WEST SUSSEX COUNTY COUNCIL CONSULTATION

TO:	Arun District Council FAO:Simon Davis
FROM:	WSCC - Highways Authority
DATE:	6 November 2019
LOCATION:	Aldingbourne Nurseries Church Road Aldingbourne Chichester PO20 3TU
SUBJECT:	AL/85/19/PL Retention of existing School Shop. This application is a Departure from the Development Plan.
DATE OF SITE VISIT:	n/a
RECOMMENDATION:	Advice
S106 CONTRIBUTION TOTAL:	n/a

Title PROPOSED SITE PLAN	
Project SCHOOL SHOP REFURBISHMENT NYTON ROAD ALDINGBOURNE CHICHESTER	
Client CAMPUS & CO	
Drawn by	Richard Hollands [Grove Design UK]
Date	October 2019
Scale	1 : 500 @ A3
Drawing No	19-10-GD-240-03A
Amendments	(A) Bldg scale check

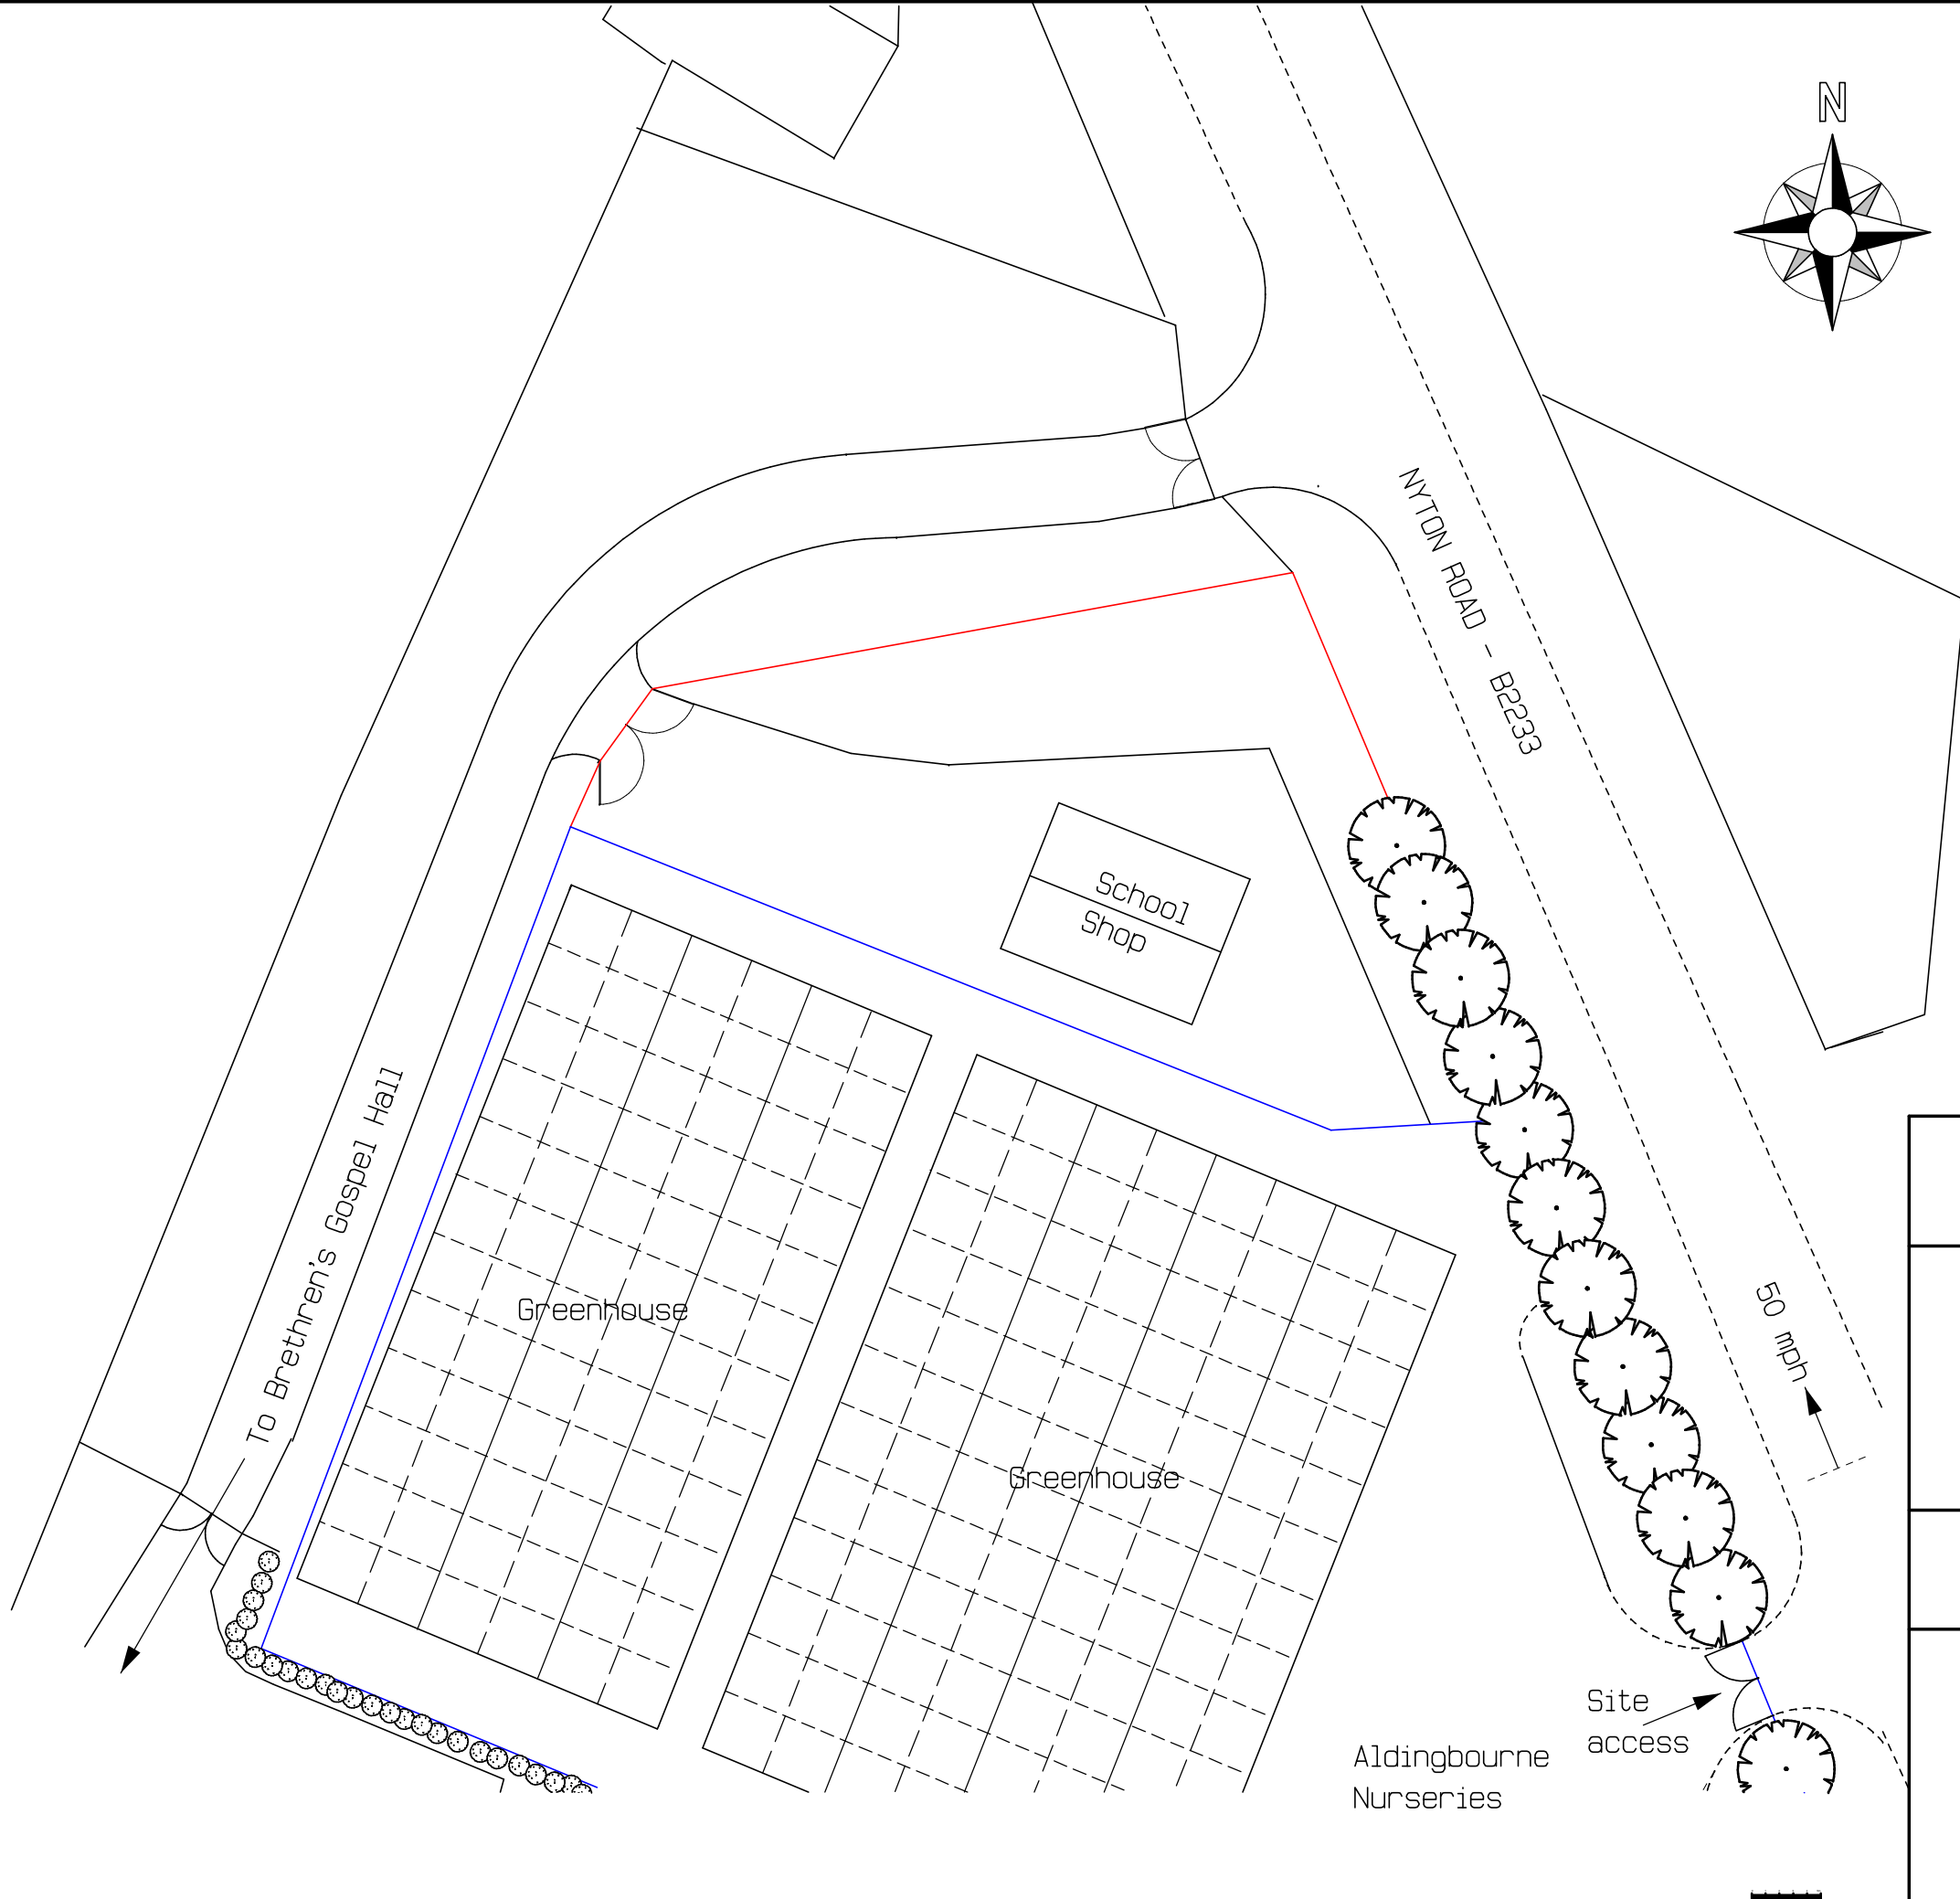
Access to the school shop will be taken from this access road, which is privately maintained. Ideally this should be designed to provide good visibility in both directions with adequate width to allow cars to enter and exit safely. The car park will accommodate up to 15 cars. As the site is considered to be a sui generis use class no parking standards can be applied. As such WSCC would advise any spaces should be created in line with manual for streets guidance of 2.4m x 4.8m. The layout should also allow for parking and turning enabling cars to exit the site in forward gear.

No part of the development shall be first occupied until the vehicle turning space has been constructed within the site in accordance with the approved site plan. This space shall thereafter be retained at all times for their designated use.
